3. **Project# 1009814**  
 13DRB-70666 MINOR - PRELIMINARY/  
 FINAL PLAT APPROVAL

JACKS HIGH COUNTRY INC agent(s) for PAMELA J SMITH request(s) the above action(s) for all or a portion of Lot(s) 23-A-1-A & 23-B-1-A, **ALVARADO GARDENS**, zoned RA-2, located on HARVEST LANE NW BETWEEN CORIANDA CT NW AND MATTHEW PL NW containing approximately .985 acre(s). (G-13) **THE PRELIMINARY/FINAL PLAT WAS APPROVED WITH FINAL SIGN OFF DELEGATED TO TRANSPORTATION FOR EXHIBIT REVISION AND TO PLANNING FOR UTILITY COMPANY SIGNATURES.**

DRB CASE ACTION LOG - BLUE SHEET

Project Name: ALVARADO GARDENS

# PLAT OF LOTS 23-A-1-A-1, 23-A-1-A-2 AND 23-B-1-A-1 ALVARADO GARDENS, UNIT 1

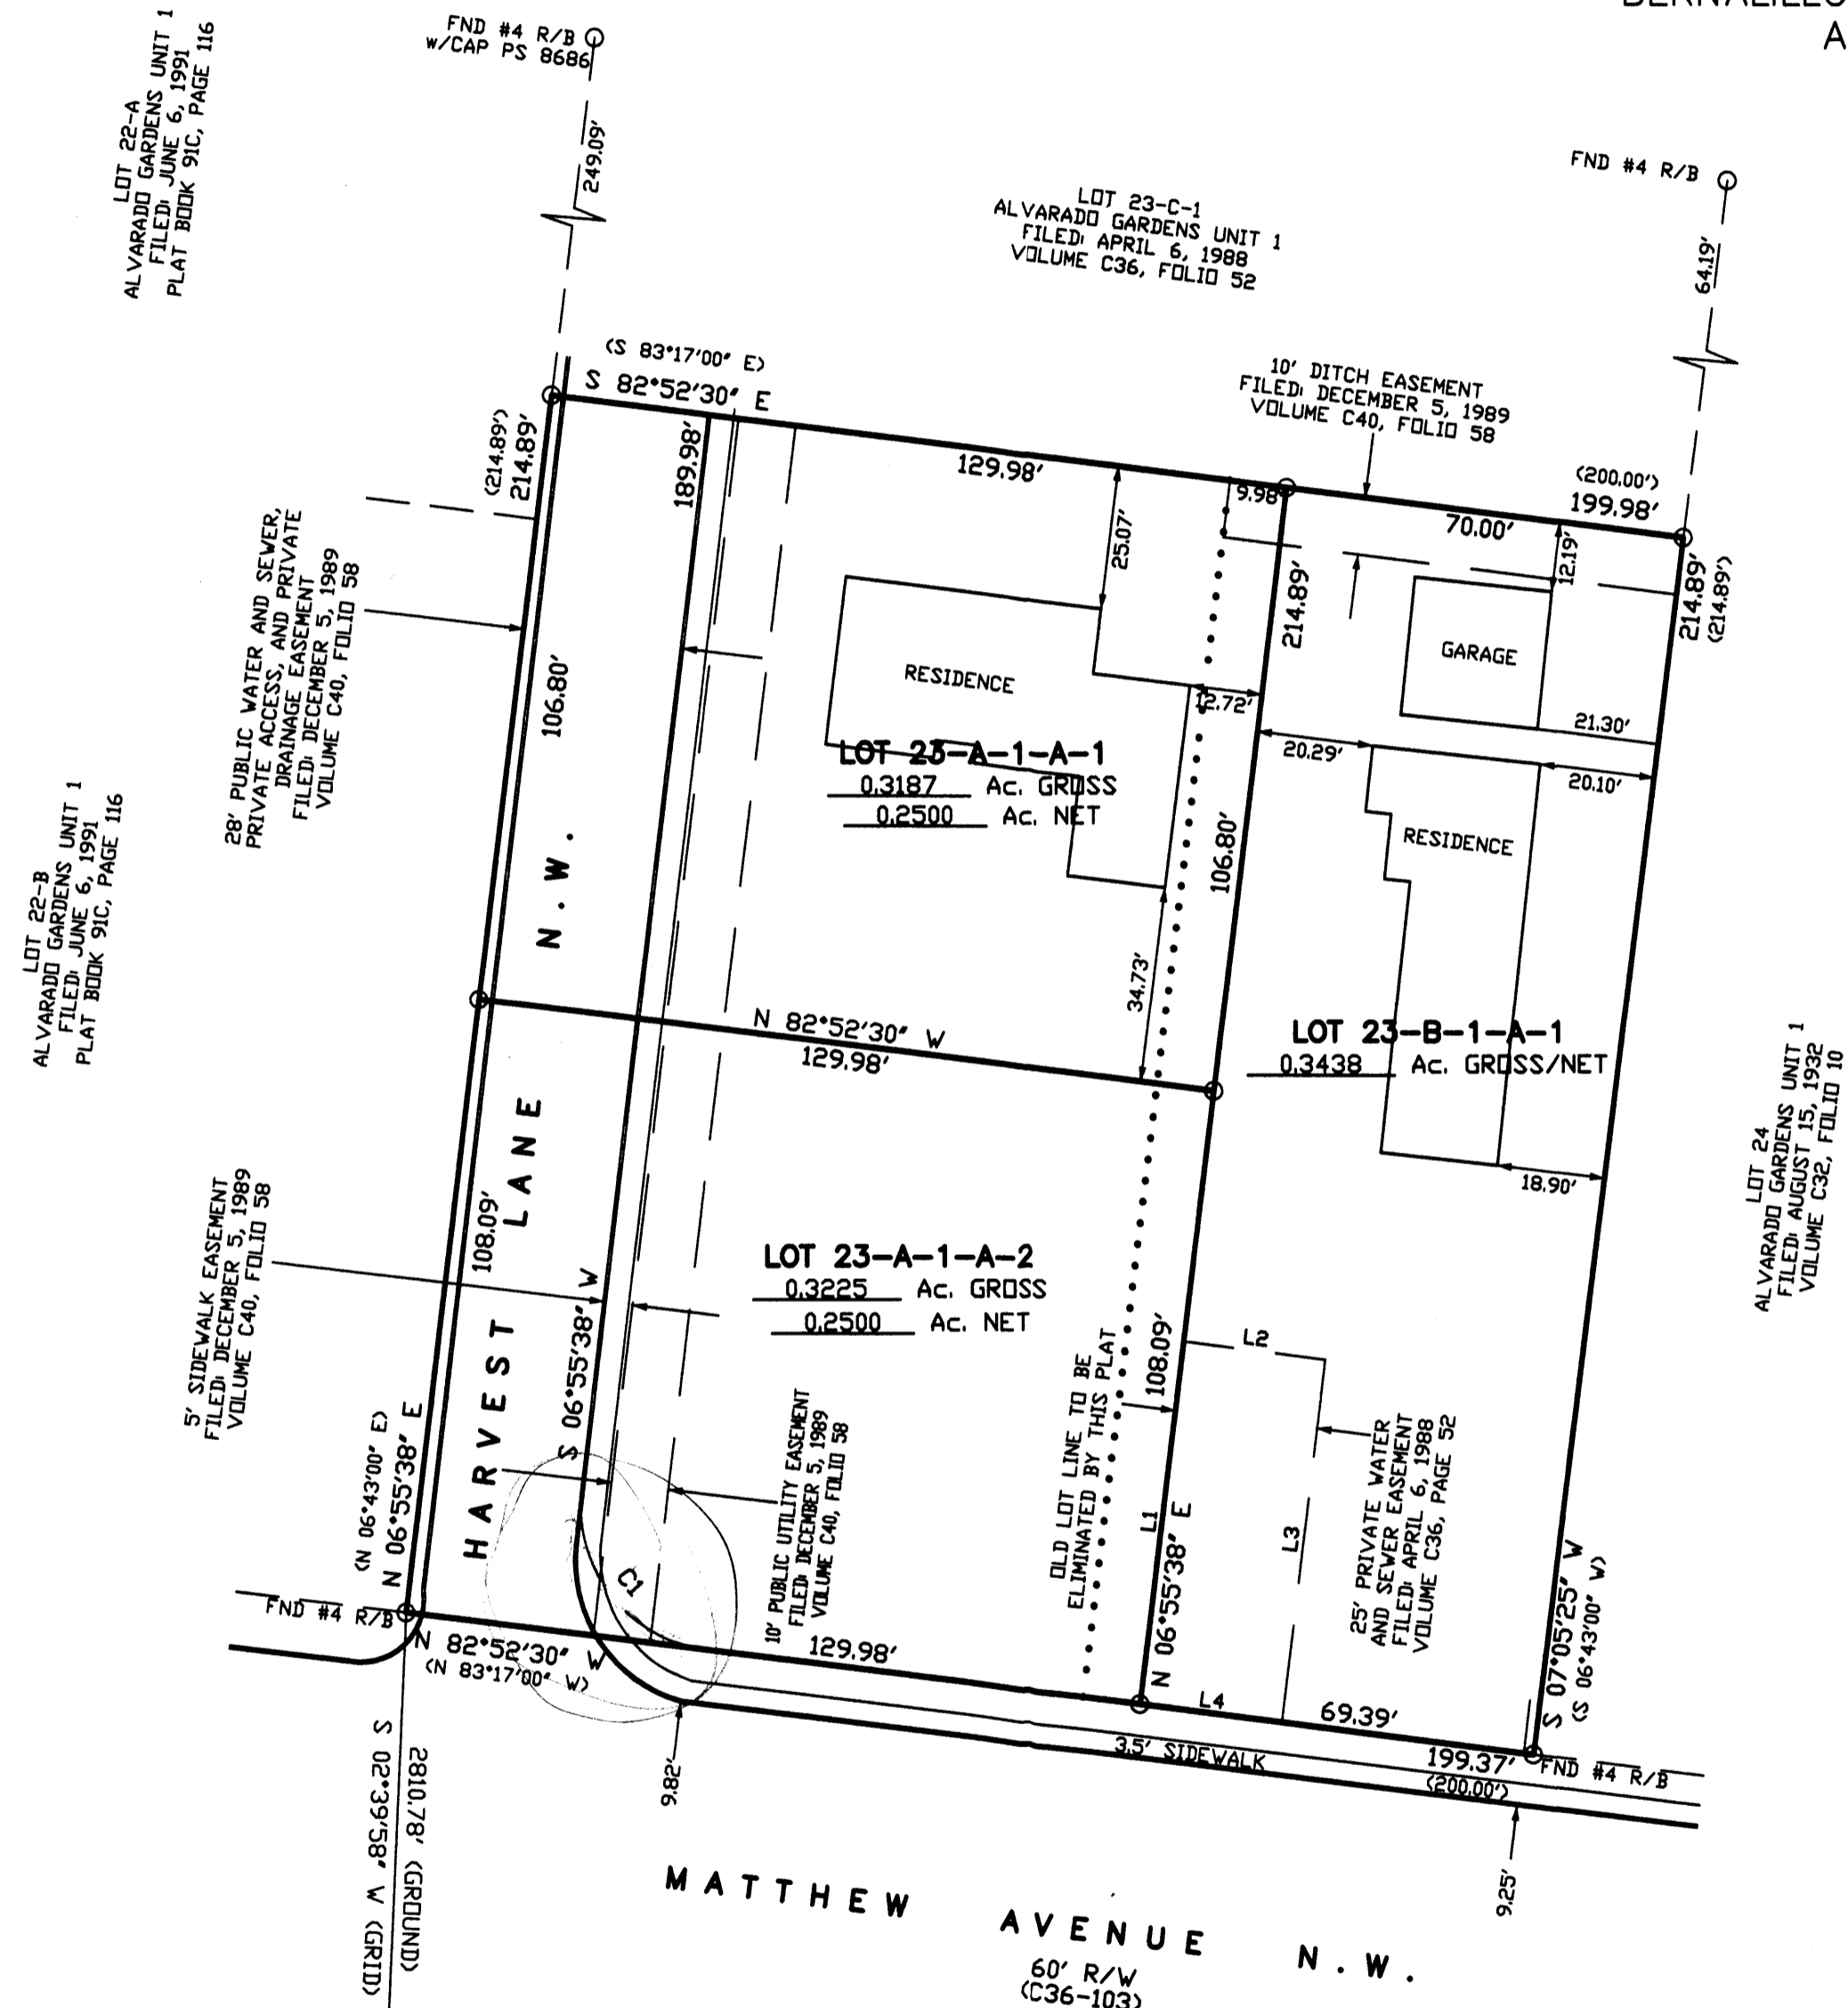
*provide exhibit, need adequate sidewalk E-mex*
